From: Ian Brewster
Sent: 22 February 2012 11:39
To: Eve Hearsey
Subject: RE: FORMAL CONSULTATION - FG/16/12/ - COUNTRY FAYRE (ASDA), LITTLEHAMPTON ROAD, FERRING
 Dear Eve,

I understand that approval for the ASDA development has been granted. Regarding the planting of trees within the site my comments are based purely from the proposed site plan (scale 1:500), as follows;

This development at Country Fayre has already been approved and Asda wish to make some changes to the overall scheme which are identified within this application for a Minor Material Amendment (MMA). One of the changes being that the landscaping/planting will be increased to that of the earlier permission.

Proposed Site Plan

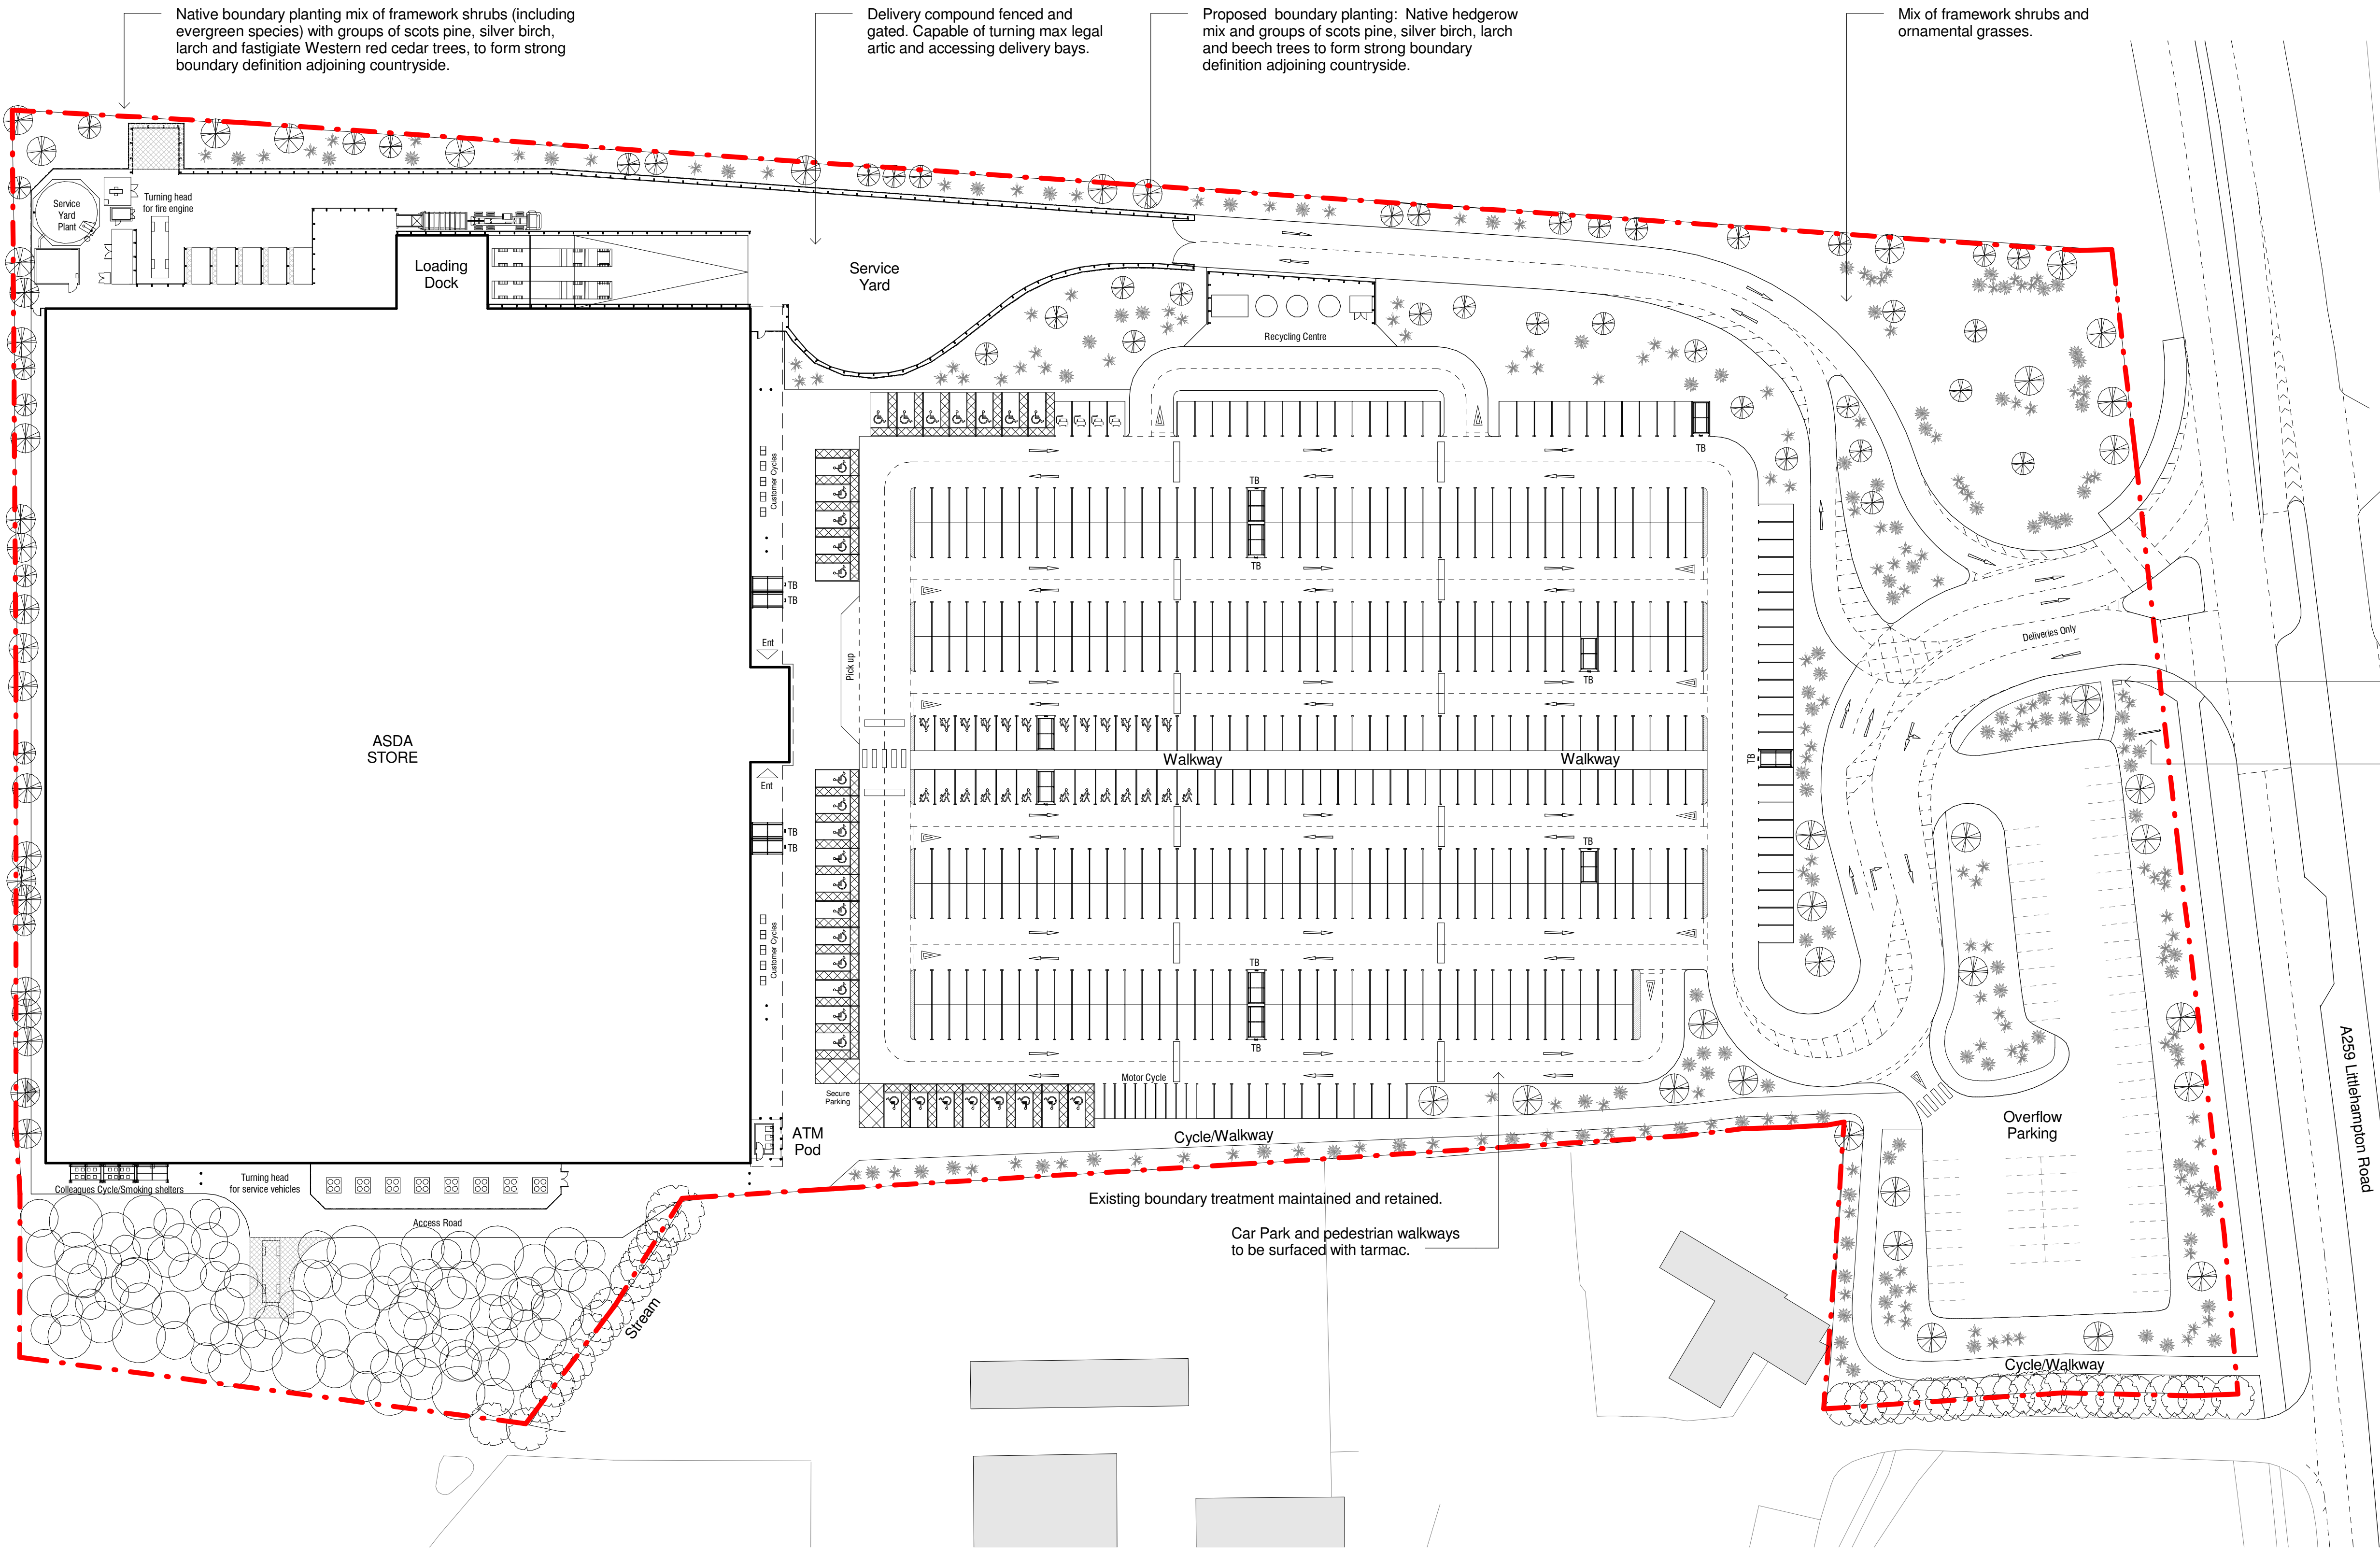
The width of the western boundary measures 3.5m. The proposed planting of Scots Pine, Silver Birch and Beech trees will mature and their branches will overhang the access driveway to the loading dock/Service yard. Vehicles using this route will be high sided HGV. Tree planting would need to set at a sufficient distance to reduce the need for drastic pruning work, eliminating the creation of an un-balanced line of trees and increase their life expectancy. It is therefore recommended that the verge is widened to accommodate broad spreading trees or that they are planted at a distance of 0.5m from the boundary to allow at least 3m lateral branch growth without the need for pruning hard back from the driveway. Please note that the planting of Larch is not recommended due to its recent association with the fungal disease Phytophthora. I would suggest provenant and locally sourced English Oak as a possible replacement for Larch.

The overflow car park to the north east is opposite to the planting area (approximately 30x40m) north west and from a visual perspective as viewed from the A259 Littlehampton Road appears unbalanced. It would be appropriate to provide a similar planting scheme/provision for space by halving the overflow car park and supplement the mix of framework shrubs and grasses with trees, suggesting tall, cleared stemmed Scots Pine trees in groups of 3. This would effectively soften and enhance the entrance, adding a natural and prominent landscape feature that would become visible from the highway.
